KITTITAS COUNTY
DEPARTMENT OF PUBLIC WORKS

MEMORANDUM

SUBJECT: Peoh Point Large Plat

**PEOH POINT LARGE LOT SUBDIVISION  
A PART OF GOVT LOTS 1 THRU 8, IN THE SE1/4 AND THE SW1/4 OF  
SEC. 11 - T.19N. - R.15E., W.M.  
KITITAS COUNTY, WASHINGTON**

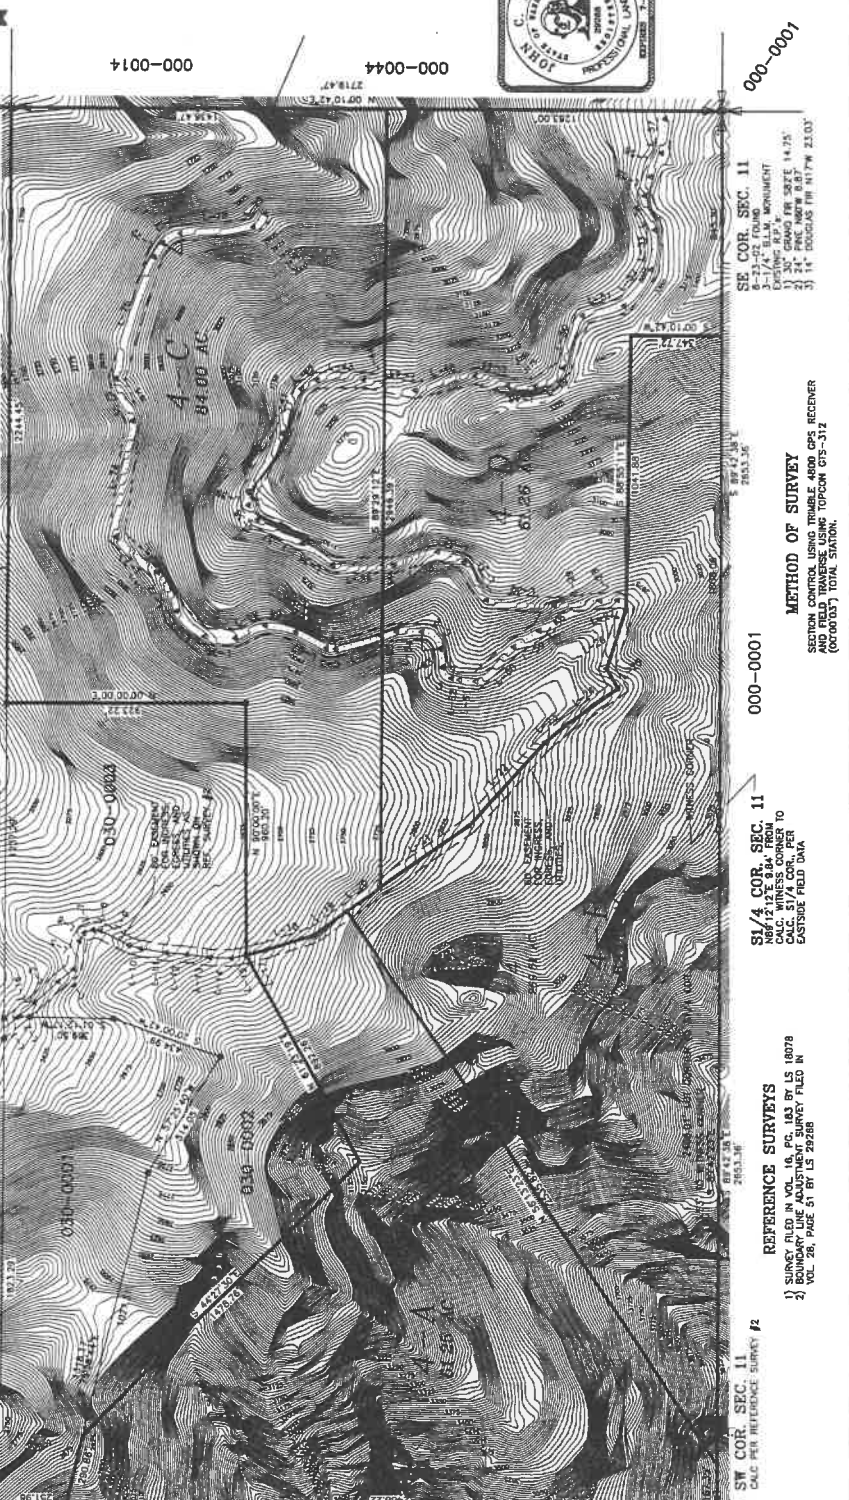
After our departments review of the final mylars it has become apparent that the applicant shall show or make reference to the access easements to the property. The question has risen that the proposed large lot subdivision did not have access to a public right-of-way. After some further review and a review of the documents that were submitted with the application it was determined that the Peoh Point Large lot Plat has access to Alice Road, which is a dedicated public right-of-way via a private easement across lot 12 of the Little Peoh Point Tract Plat. For more information please see attachments.
